Application for a non-material amendment following a grant of planning permission.

Application number 3/2021/0853

PROPOSED FRONT ELEVATION

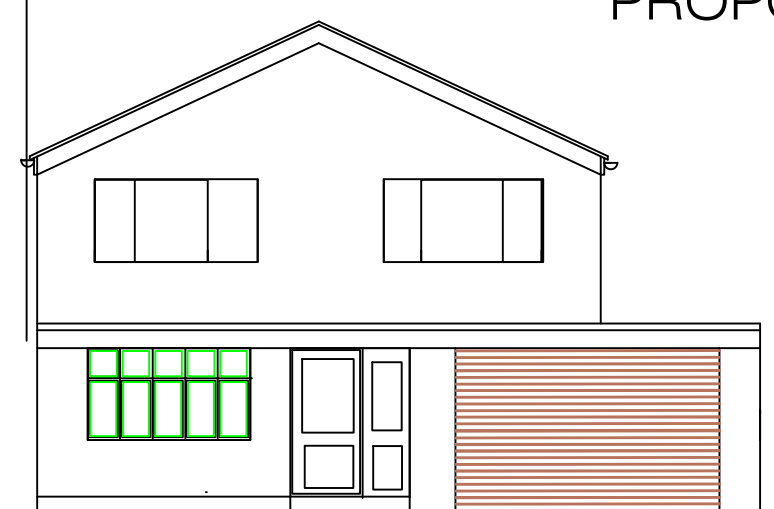
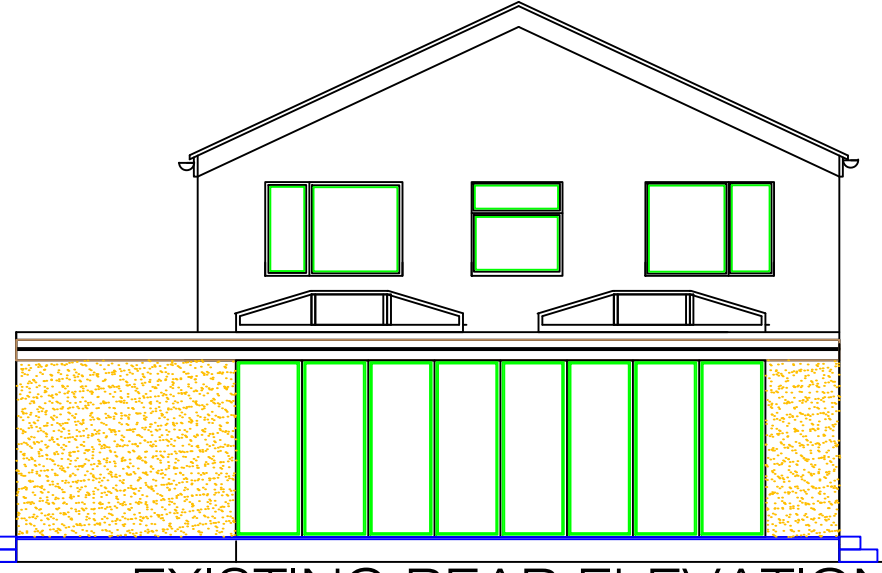
my clients would like to introduce a new window to the front elevation within the un-suite bedroom in order to this we will have to reduce the existing window within the bedroom for the layout within the bed room to work Another item we would like you to consider is that we were proposing to erect a small parapet wall over the veranda. this would purely be aesthetic

we are proposing to erect a small parapet wall over the veranda. this would purely be aesthetic
